Addendum No. 1

RE: Contract ID: C202003

NC-109 From SR-1142 (City Pond Road) to SR-1211 (Horton Road) and
3 Sections of Secondary Roads

February 19, 2008 Letting

STATE	PROJECT NO.	SHEET NO.	TOTAL SHEETS
N.C.	IDCRJ004UG	5	6
F.A. PROJECT NO.

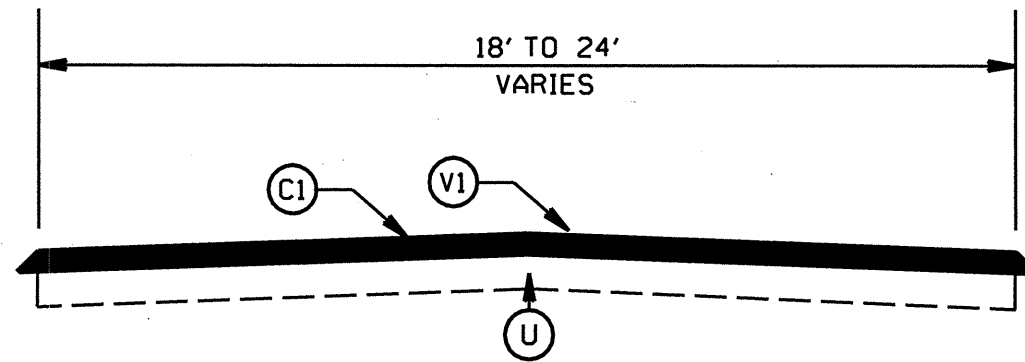
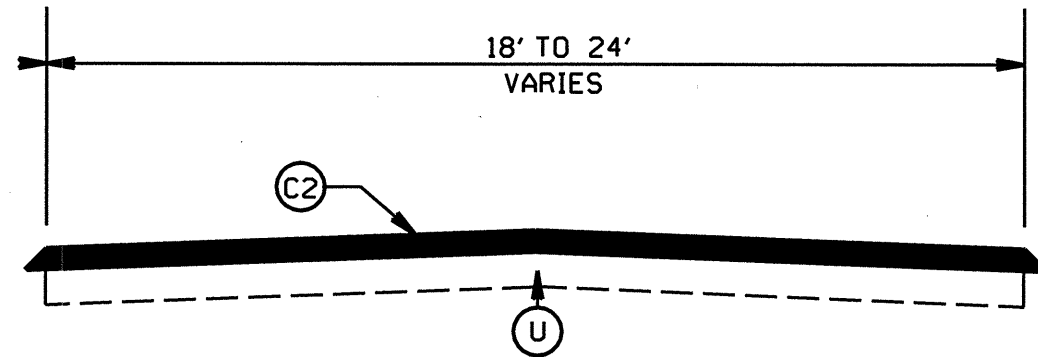
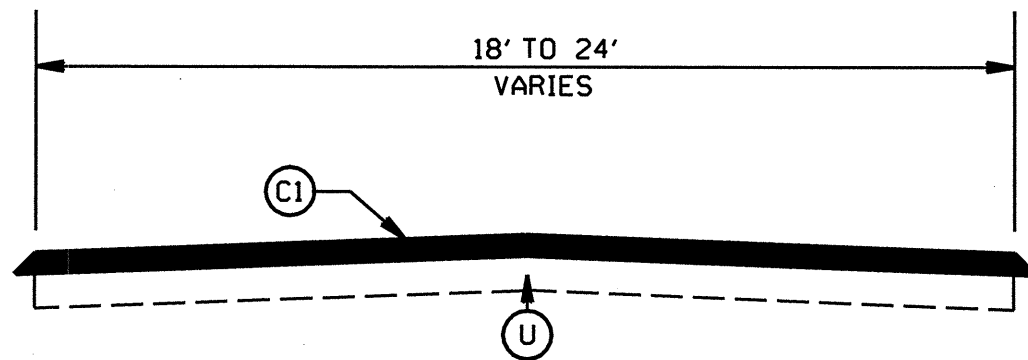
On Sheet Nos. 5 and 6 the Typical Sections and Summary of Quantities have been revised to reflect the above noted quantity change and pay item addition. Please void Sheet Nos. 5 and 6 in your sketch maps and replace with the revised Sheet Nos. 5 and 6.
